389 Congress St.  
Portland, ME 04101  
Phone: (207)874-8700  
Fax: (207)874-8716

**To:** Glen Gervais **From:** Mike Nugent/ Manager of  
Inspection Services

**Re:** Pannel Ave. (347 A005) **CC:**

Preliminary Plan Review Questions:

FIRST FLOOR PLAN
 Gosselin/Hunter

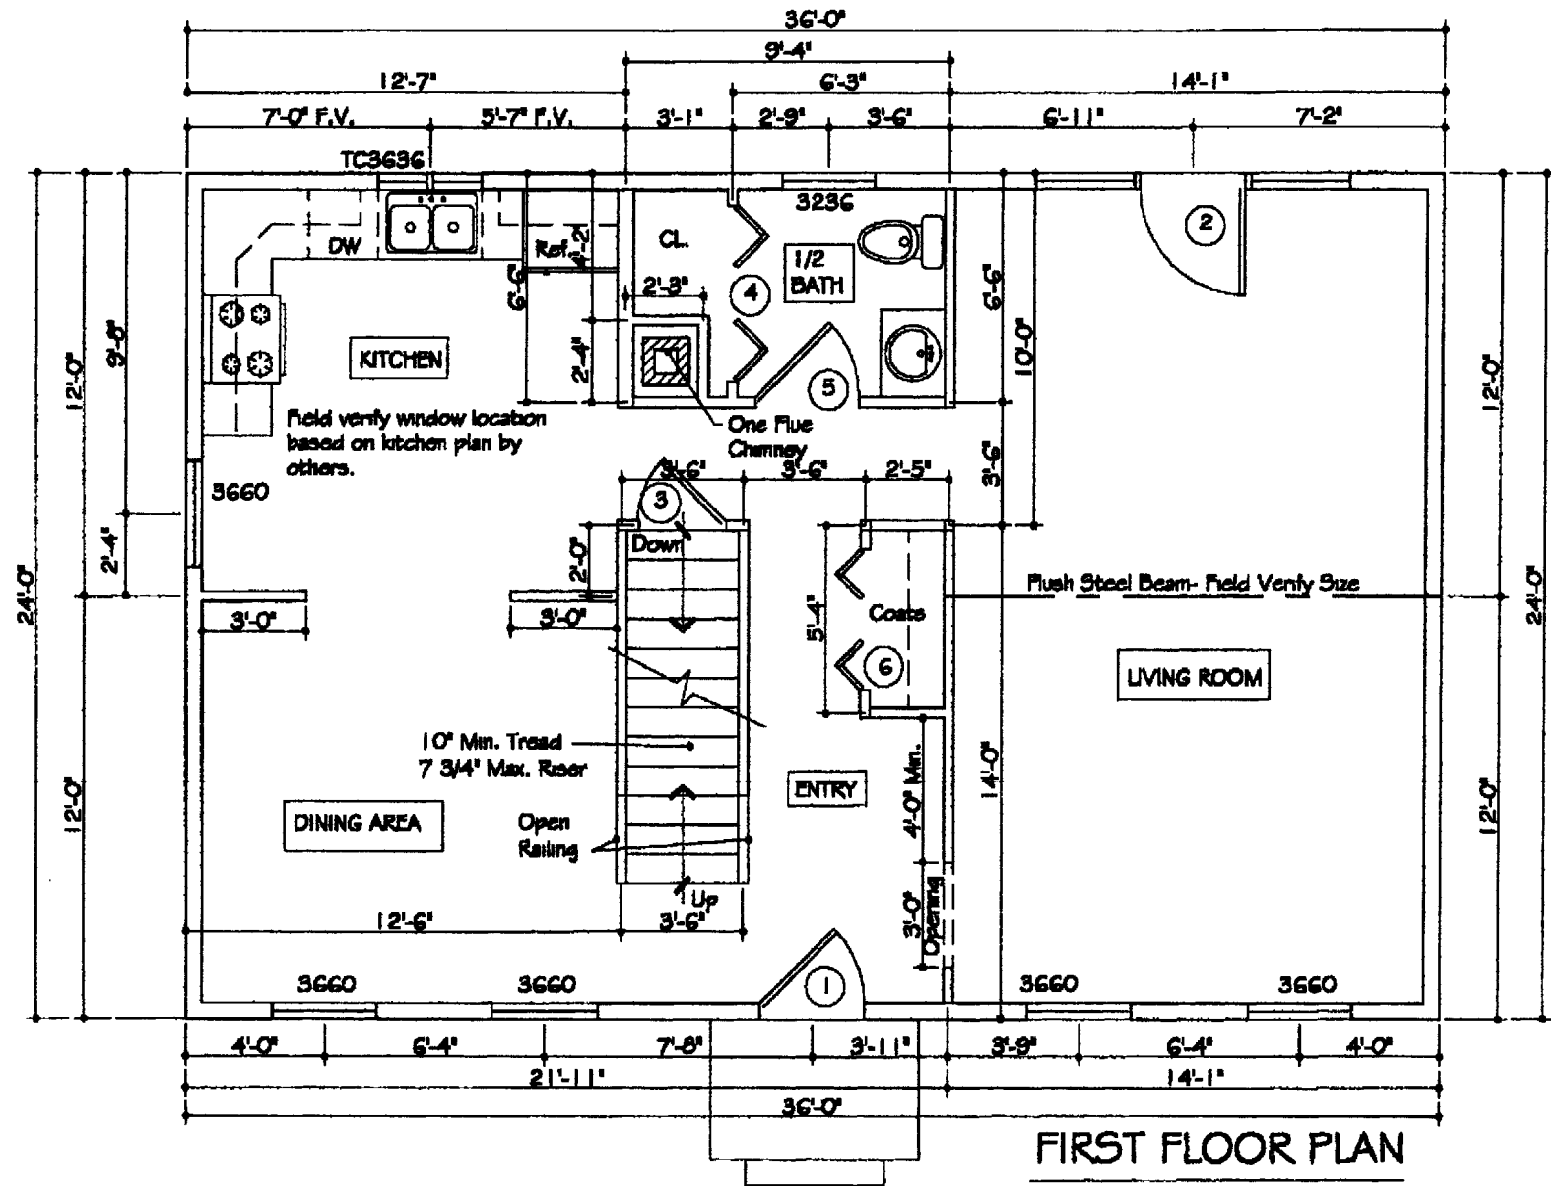
3) Headers above 1<sup>st</sup> floor “back door” and Basement Slider.

4) Code Compliant protection for the 1<sup>st</sup> floor “back door”

SECOND FLOOR PLAN

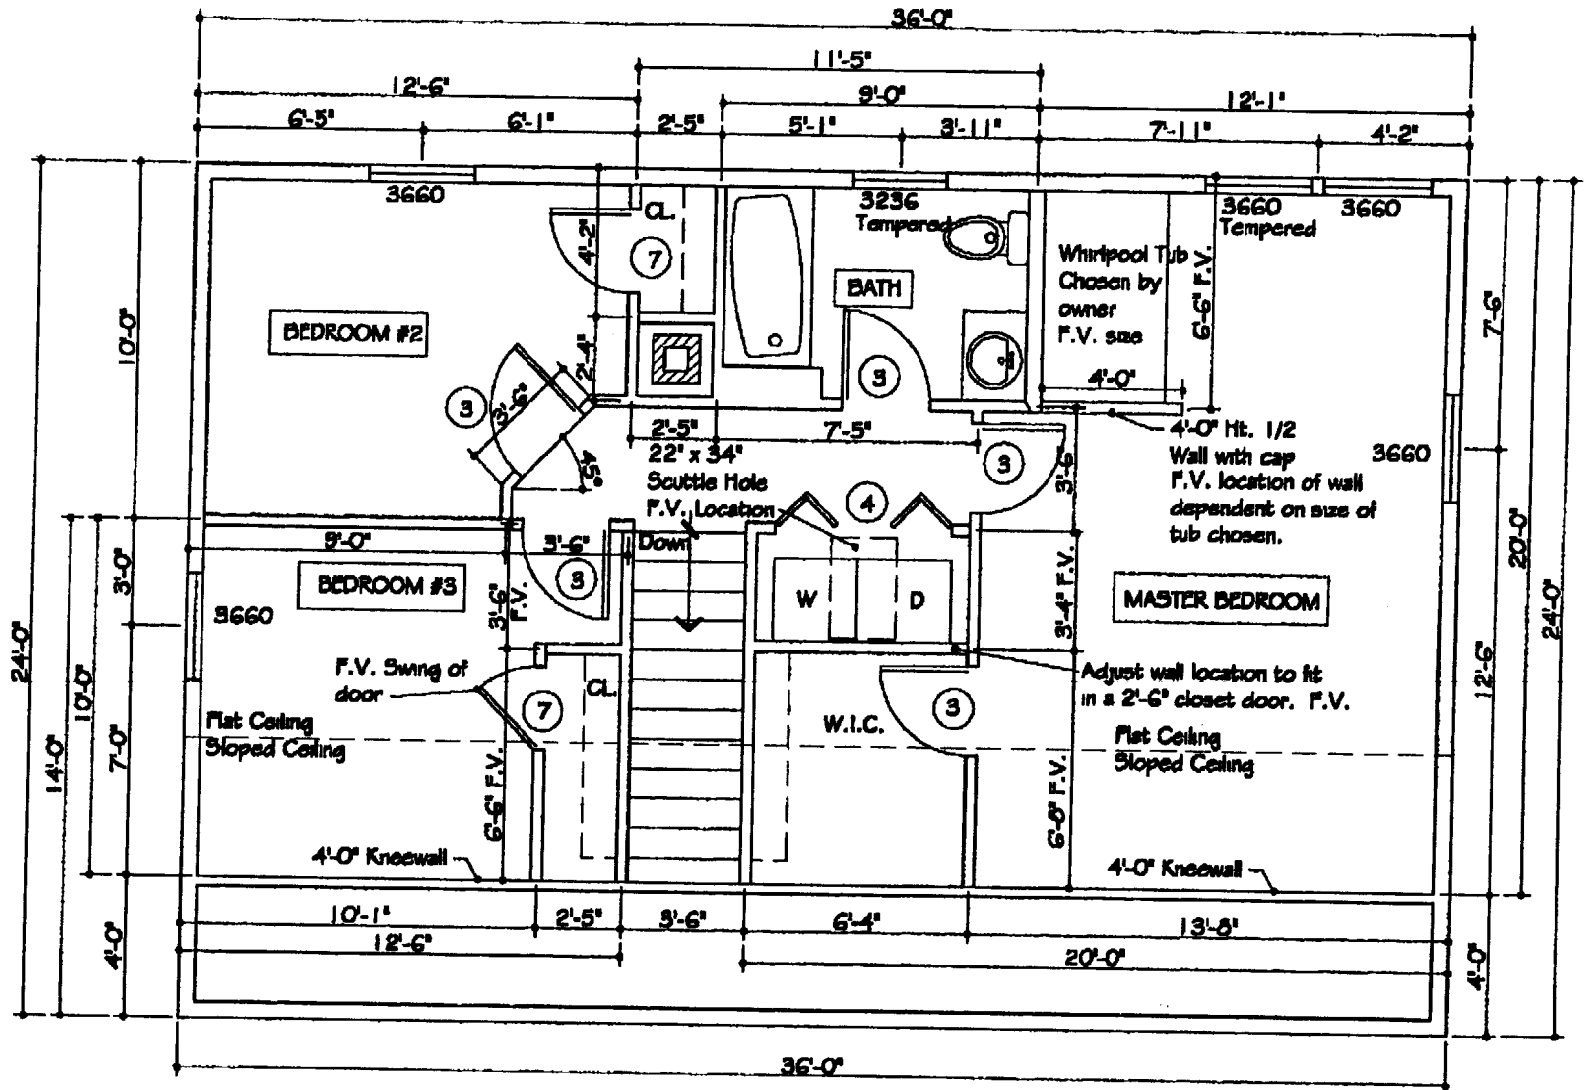
1) What is being used as the beam in the in the second floor system above the “dining room” entry.

FOUNDATION PLAN

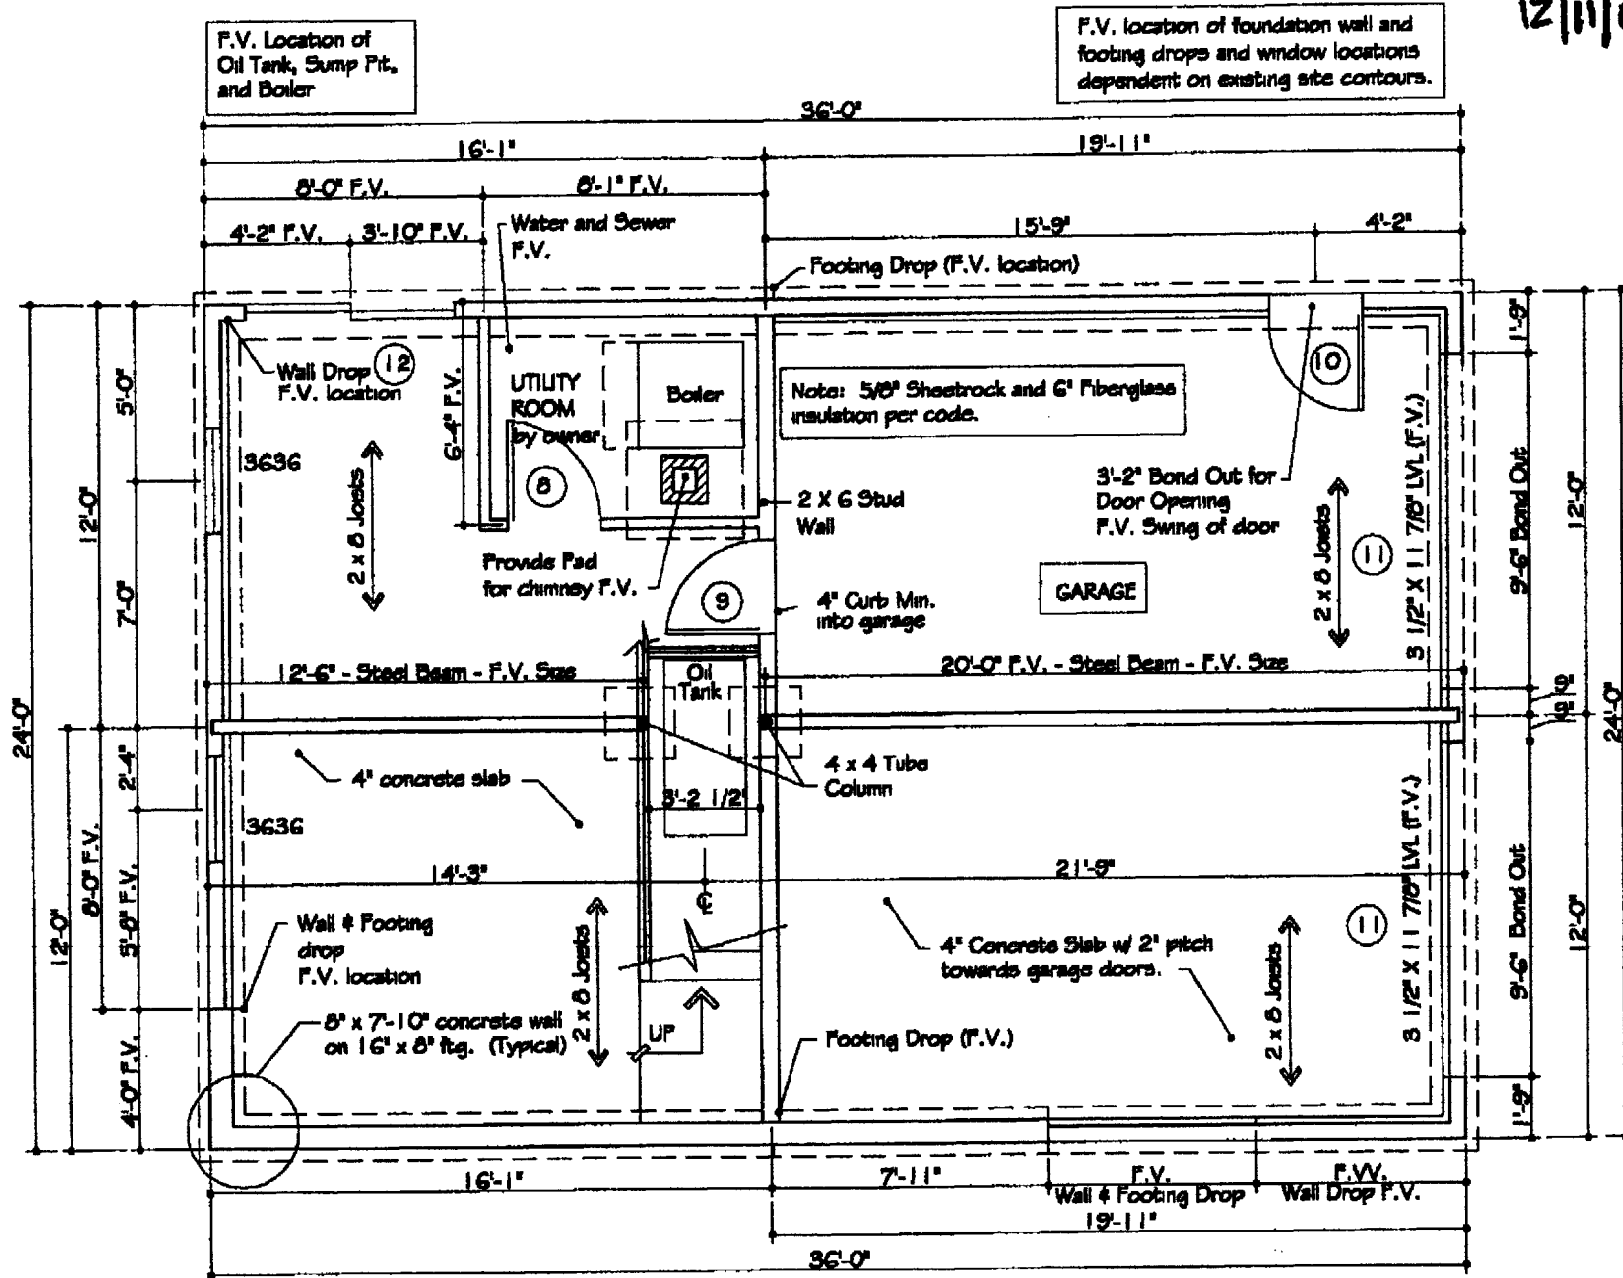
2) Foundation stepdown on daylight side is not shown.
